Thames Water Utilities Limited

Riverside Energy Park Examination – EN010093

Submission of Comments on behalf of Interested Party Thames Water Utilities Limited

**Submitted at Deadline 4
19 July 2019**

RIVERSIDE ENERGY PARK
Sound Survey Locations

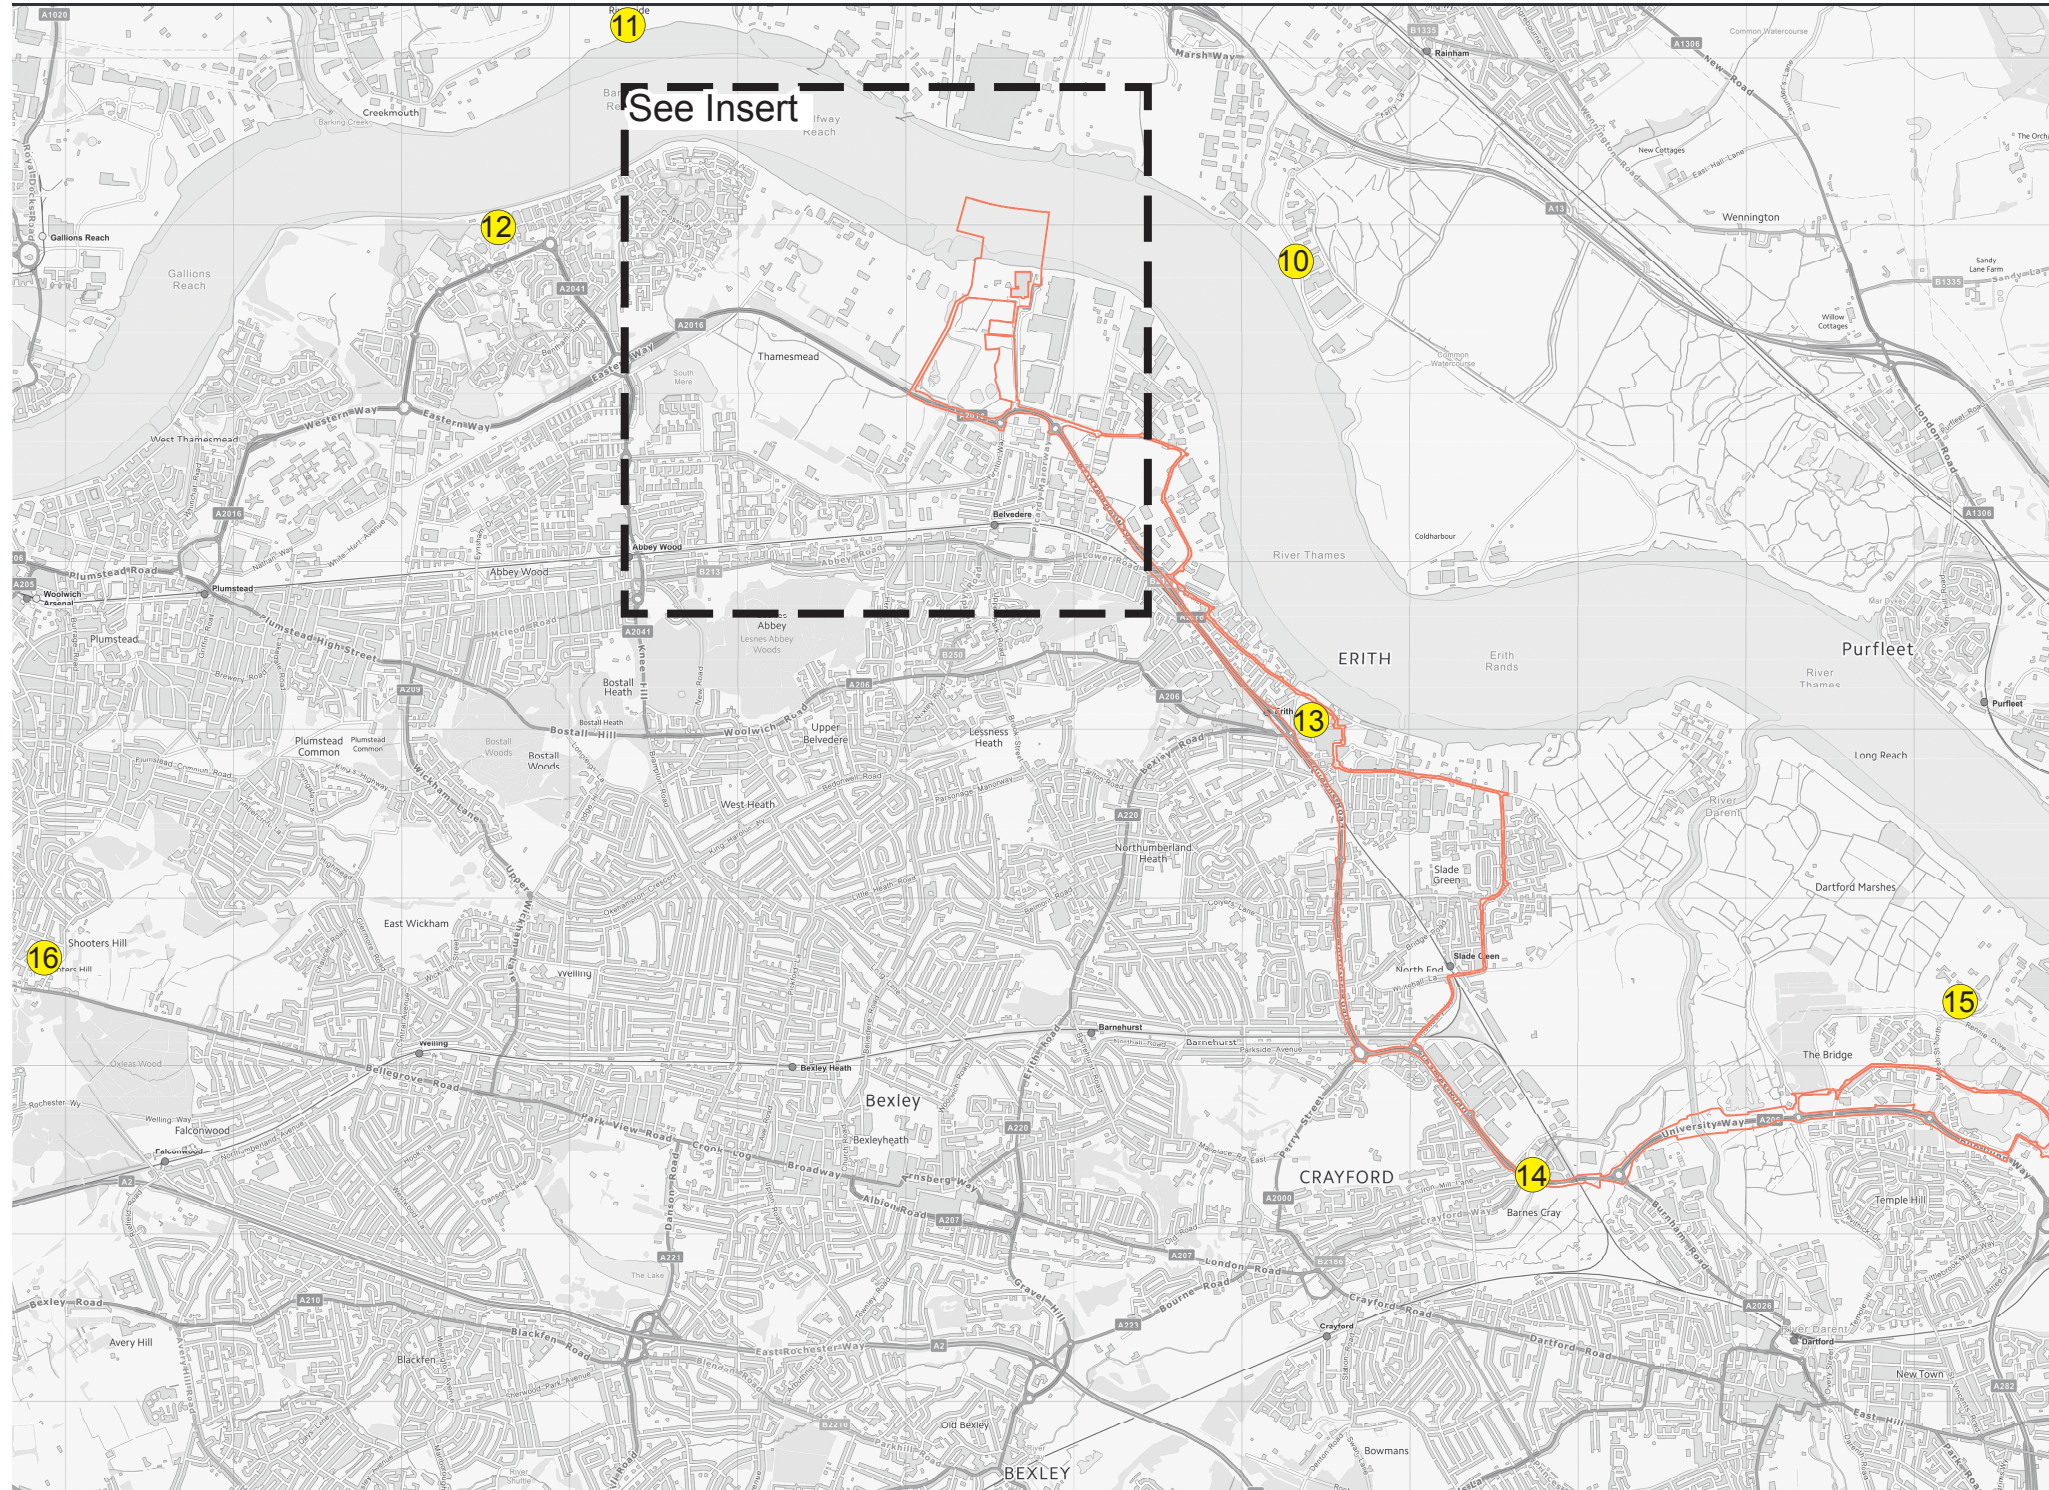
- 3.19 In paragraphs 5.3.55 – 5.3.57, the Applicant identifies that noise levels were monitored with respect to existing and predicted levels during construction of the Project at Location 3 (shown on Figure 11.10 of the Environmental Statement) which is within Crossness

Nature Reserve where breeding birds could be expected to be found. The Applicant provides that Location 3 is a good representative location relative to the Project, where birds are known to breed.

- 3.20 TWUL maintain that Location 3 is not the south-west corner of West Paddock: Location 3 on Figure 11.10 is shown located outside the gates of the Protected Area and further west than the south-west corner of the West Paddock. In any event, Lapwing breed in the centre and back of the Paddock and not the south-west corner. For this reason, it is TWUL's position that Location 3 is not an appropriate monitoring location or representative of where breeding birds could be expected to be found in the Crossness Nature Reserve. Therefore, the noise assessment at this location is inadequate in providing an indication of the noise levels anticipated by the construction of the Project.
